APPROVED
 Limited liability only review
 Permit holder responsible for
 full compliance with the code.

12/21/2022

HARNETT COUNTY
 NORTH CAROLINA

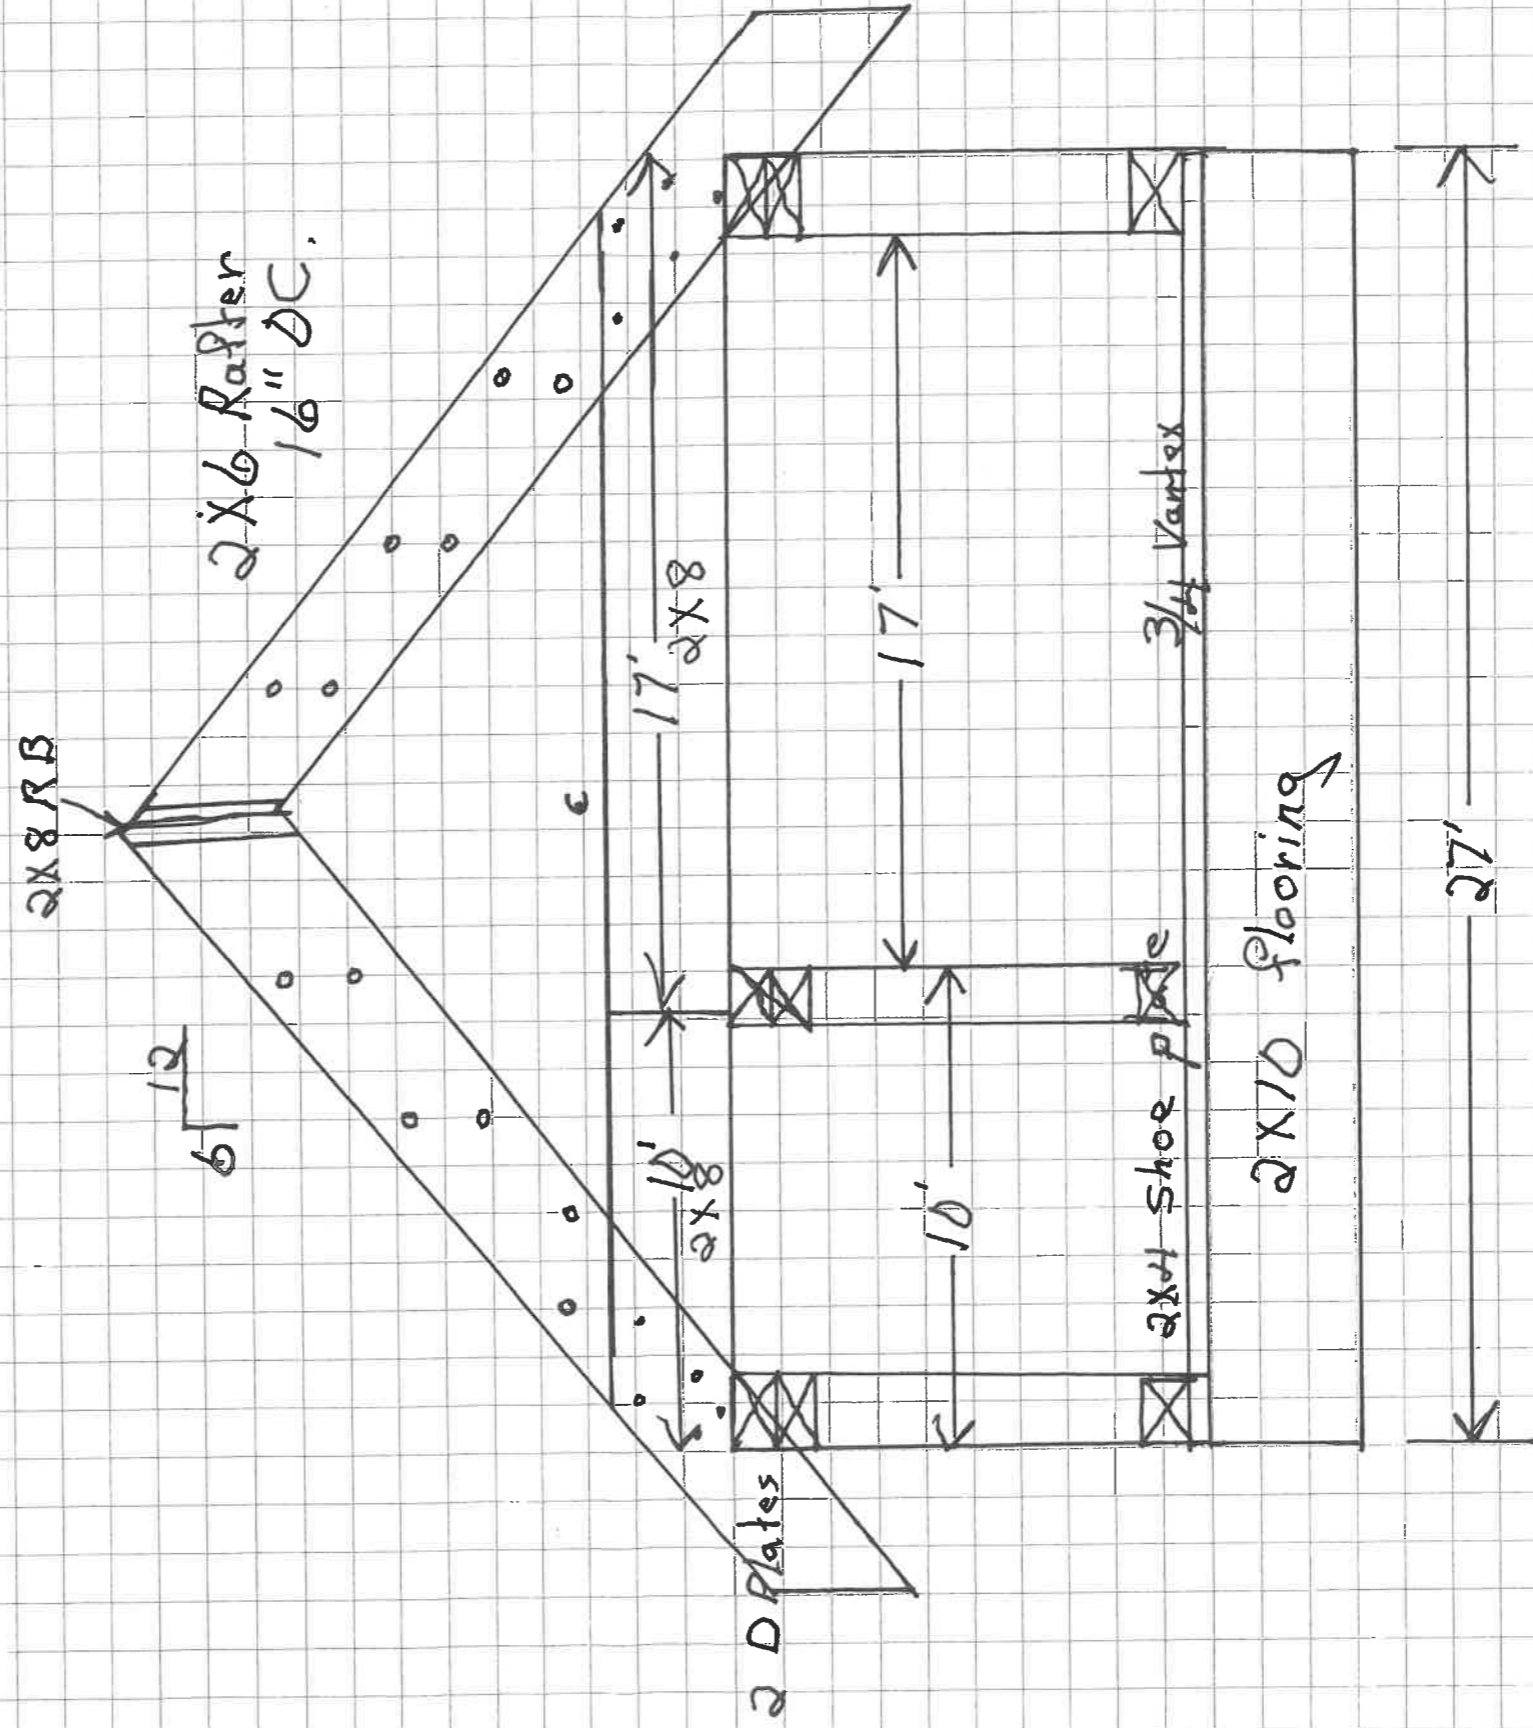
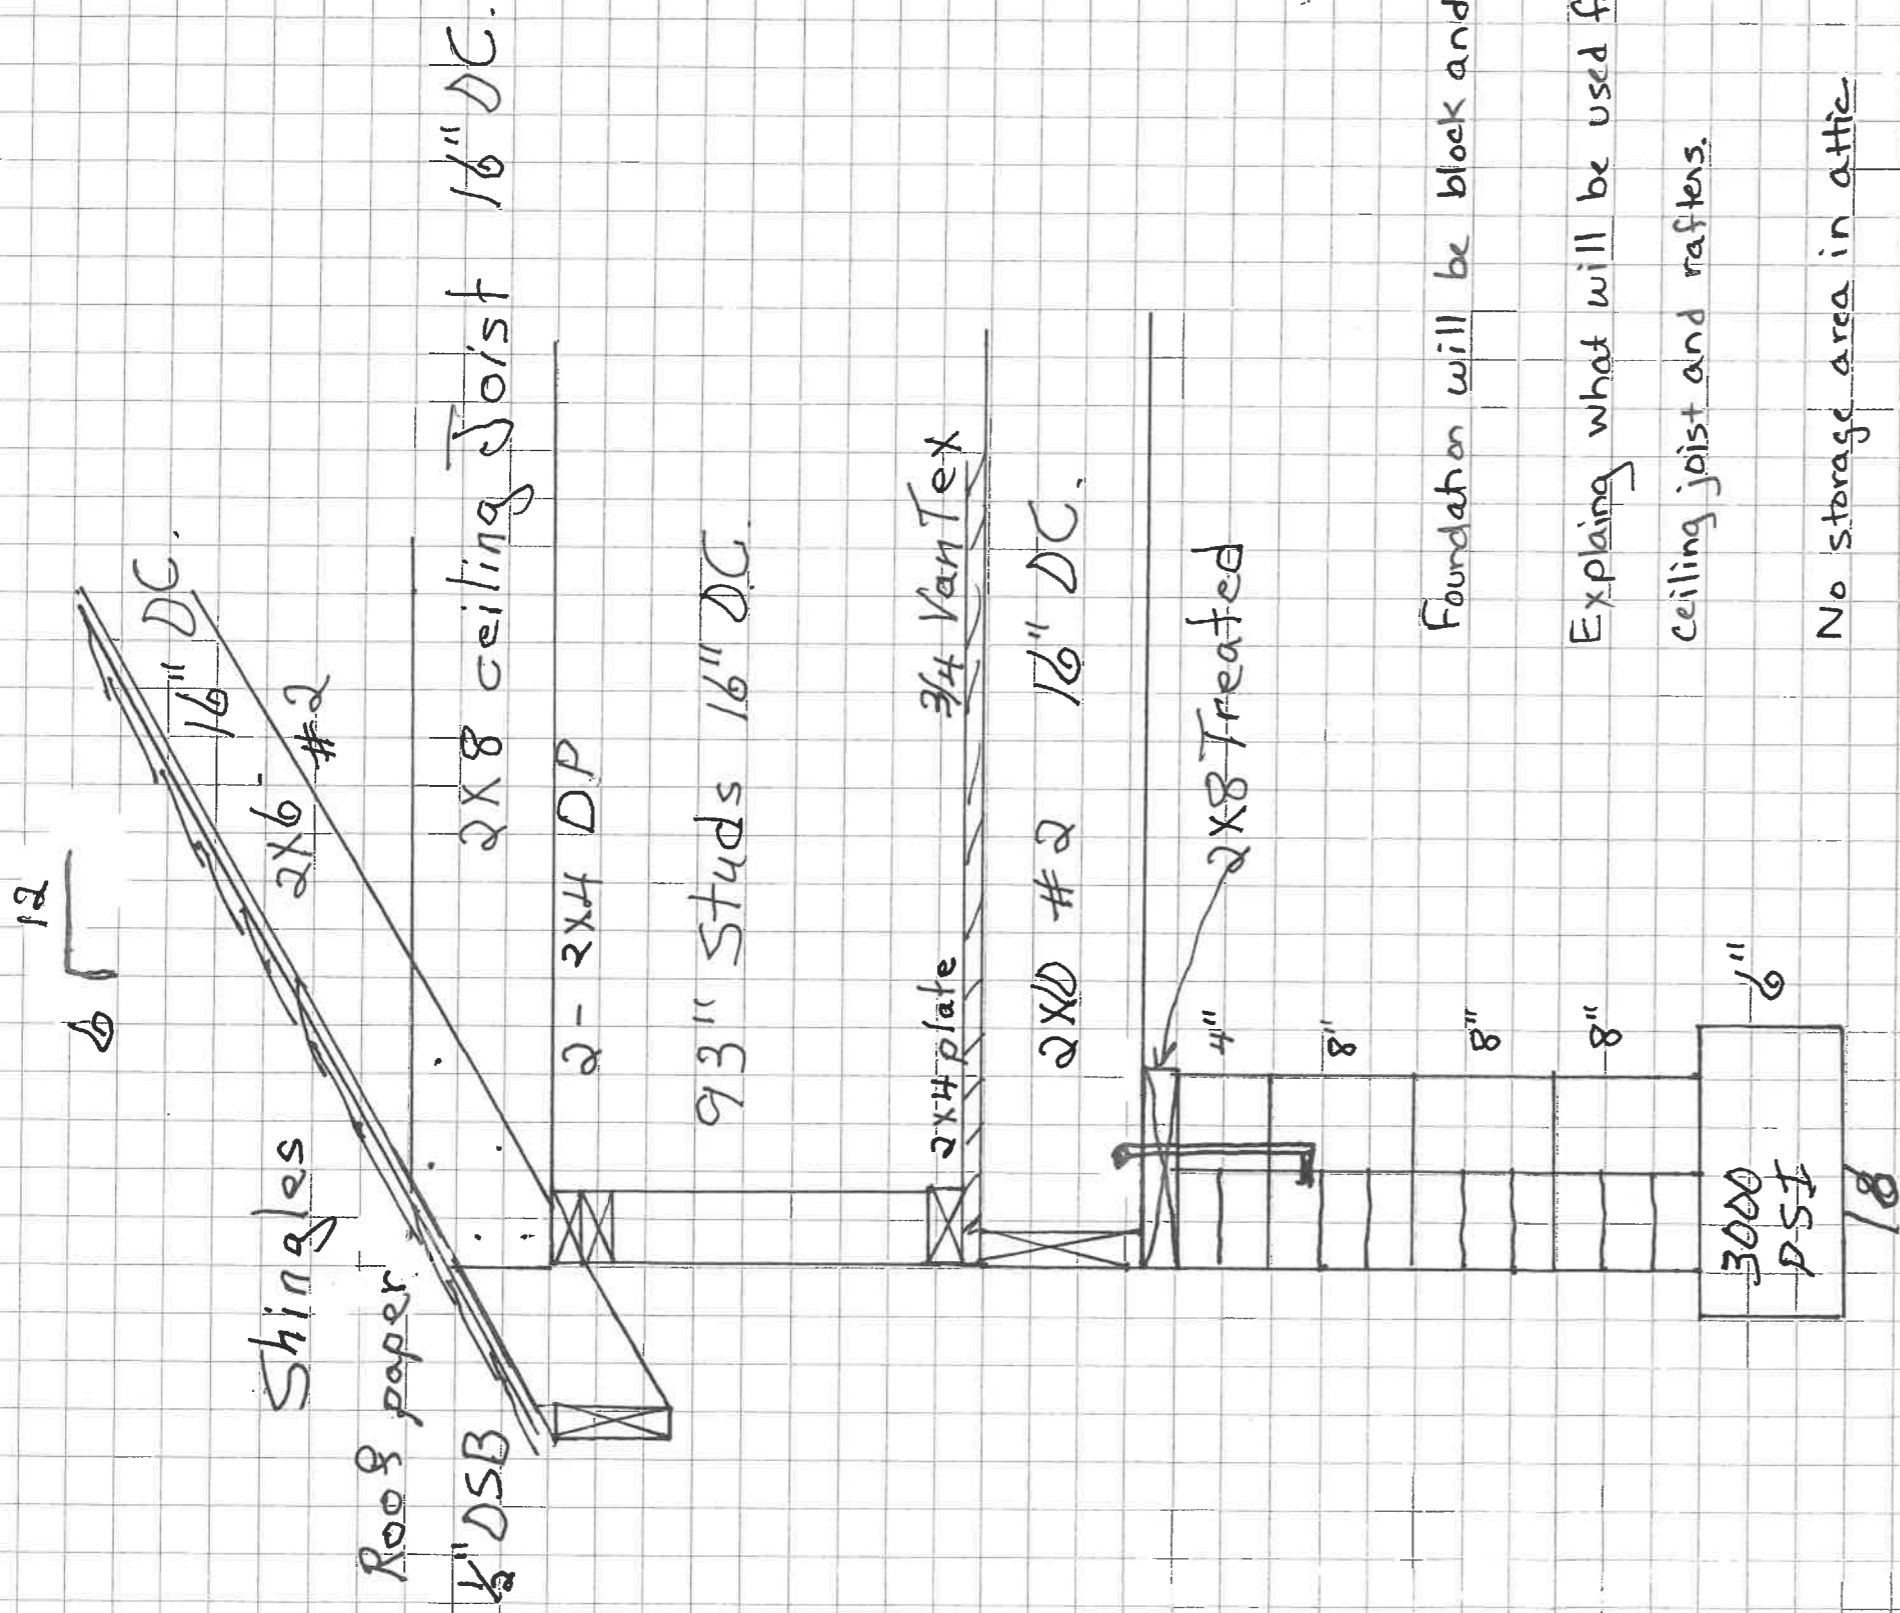
1. Must have smoke detectors inside and out.
2. Must have code compliant access to attic space.
3. See other notes on plan
